Marine Management Organisation

MMO Reference: DCO/2016/00001
Planning Inspectorate Reference: EN010080
Identification Number: 20010662

07 November 2018

Planning Act 2008, Orsted Hornsea Project Three Limited, Proposed Hornsea Project Three Offshore Windfarm Order

Figure 1.1: Location of the proposed Hornsea Three Array Disposal Site and Hornsea Three Offshore Cable Corridor Disposal Site.

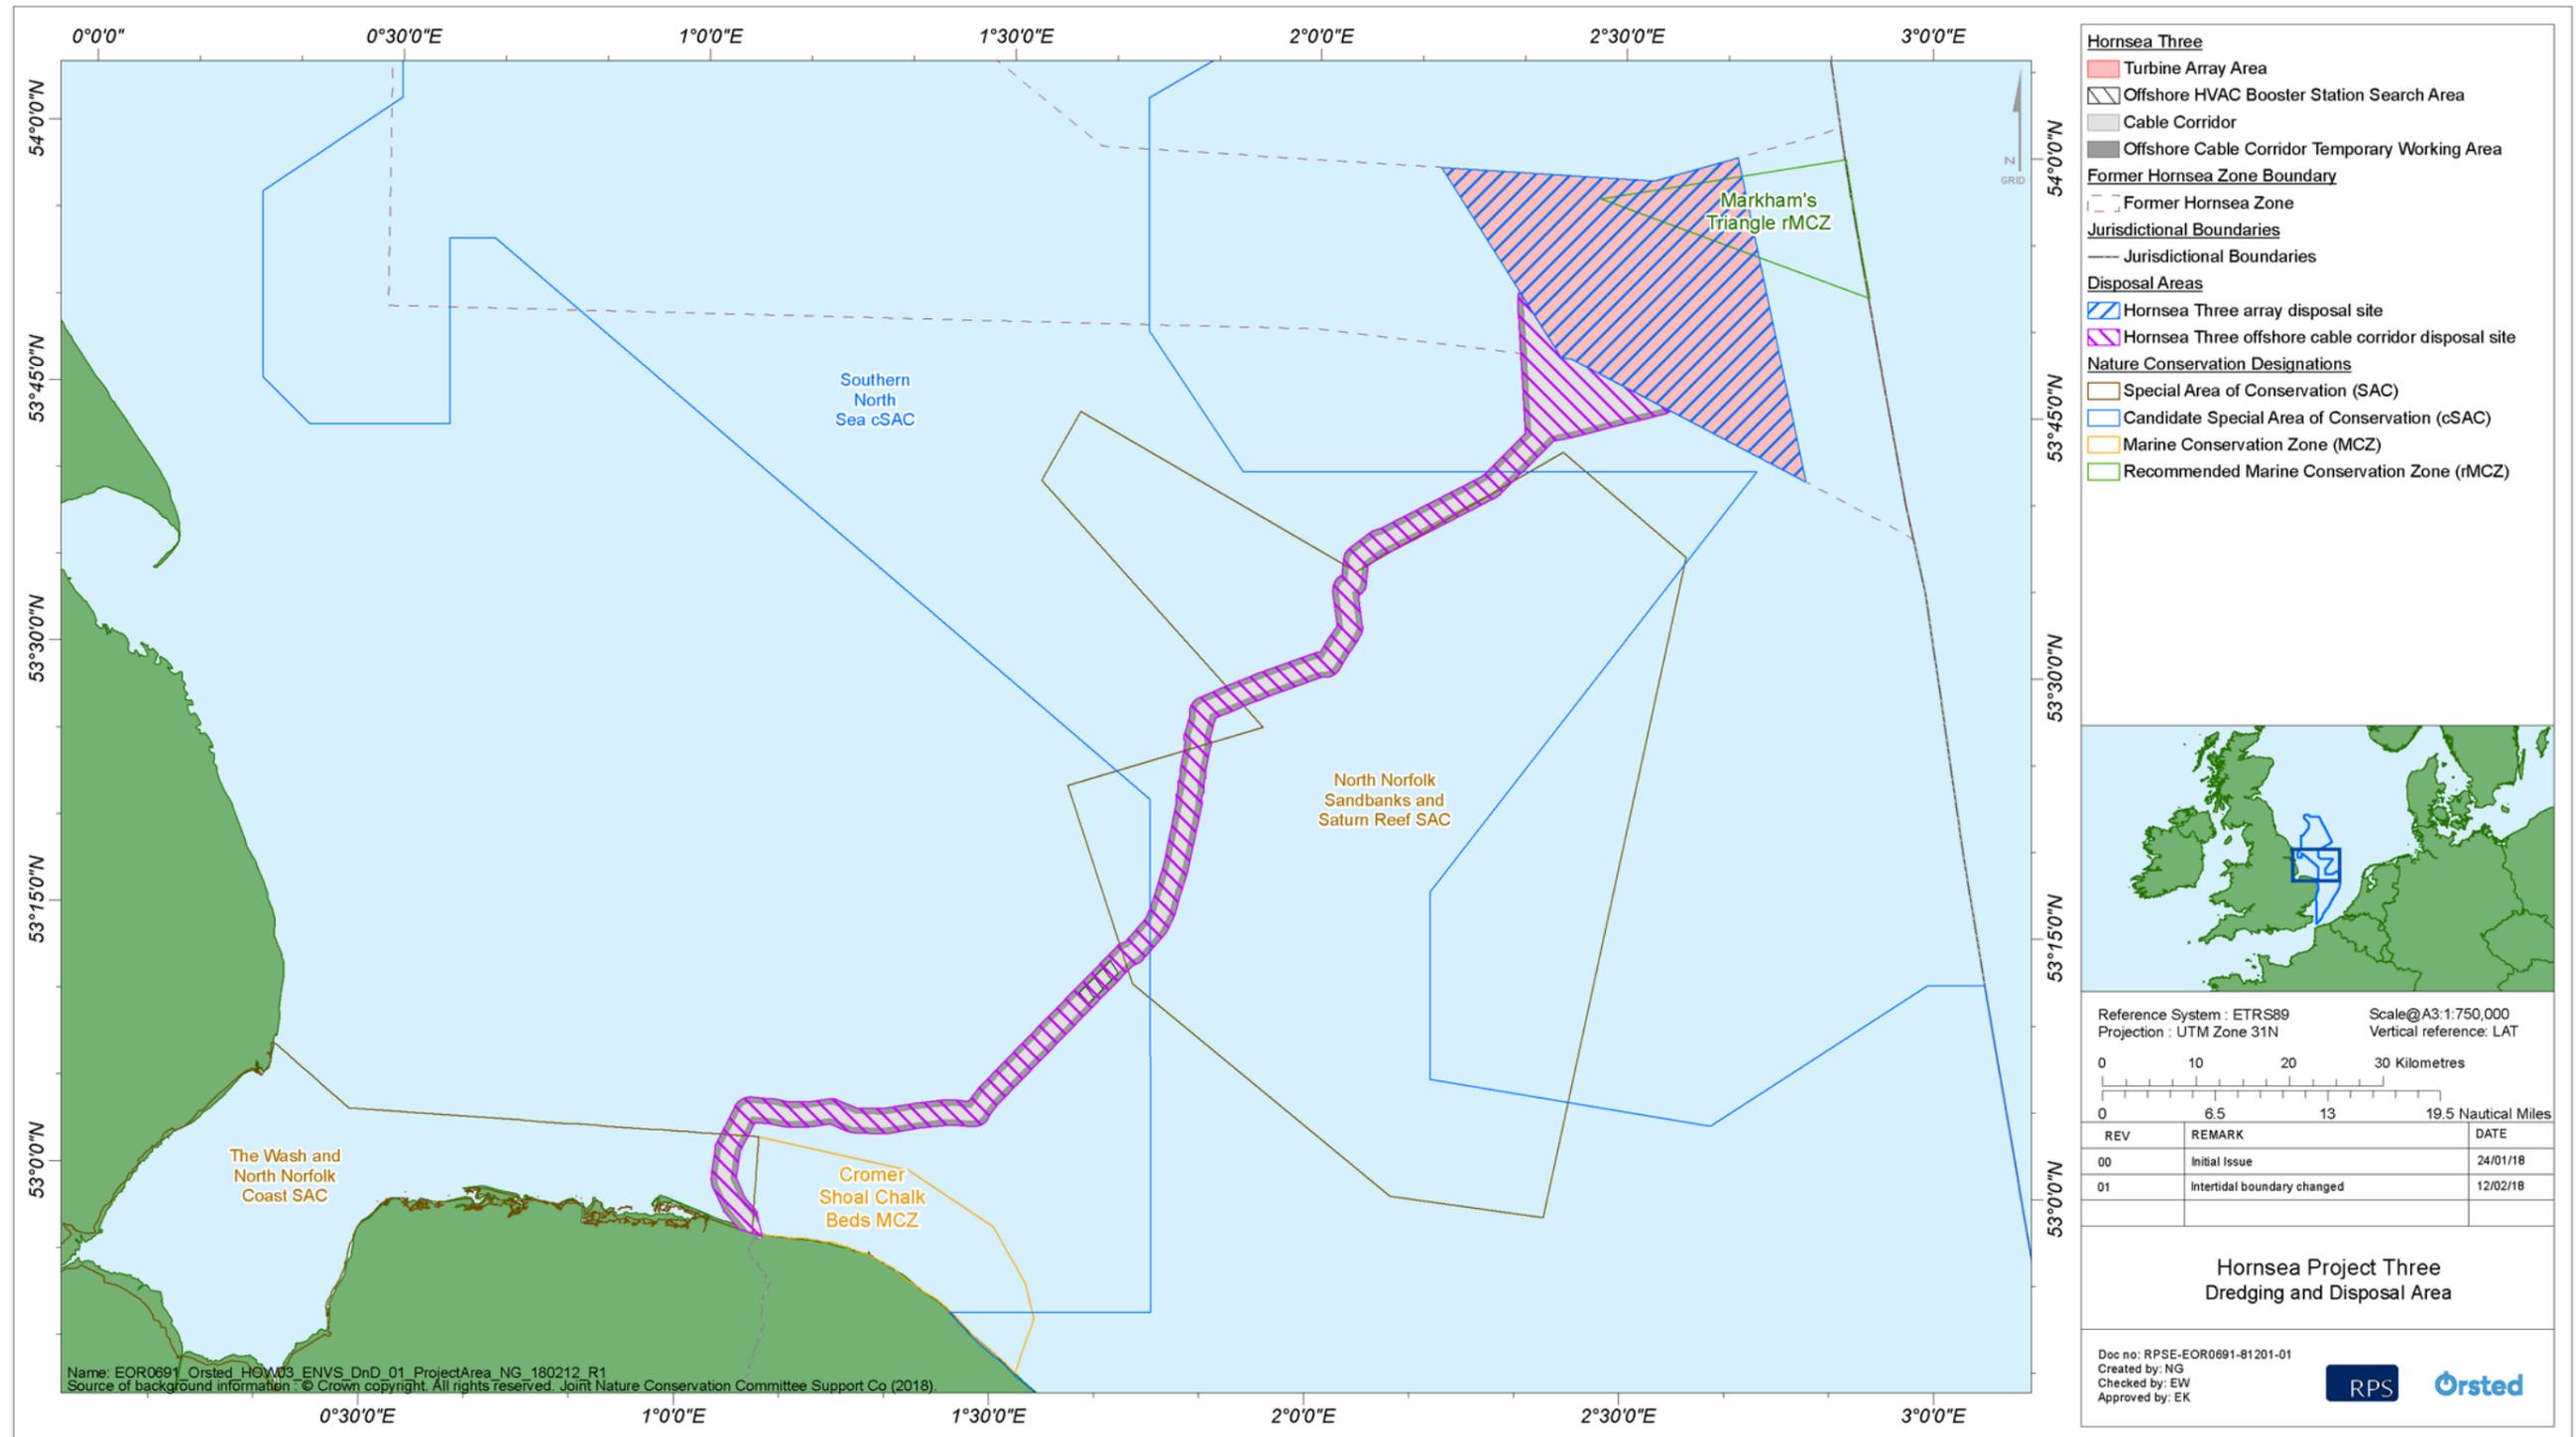
The MMO notes that disposal volumes have been clarified as 3,563,133m³. This does not align with the volume of disposal material assessed in the site disposal characterisation report and the MMO requests that this is amended for clarity. In the Applicant's Response to the Planning Inspectorate's Section 56 advice – Relationship Between Design Parameters Draft Development Consent Order and Environmental Statement (July 2018), boulder clearance has not been added to the quantity of material planned for disposal as part of the proposed development. The MMO advises that boulder clearance is regarded as an act of disposal.
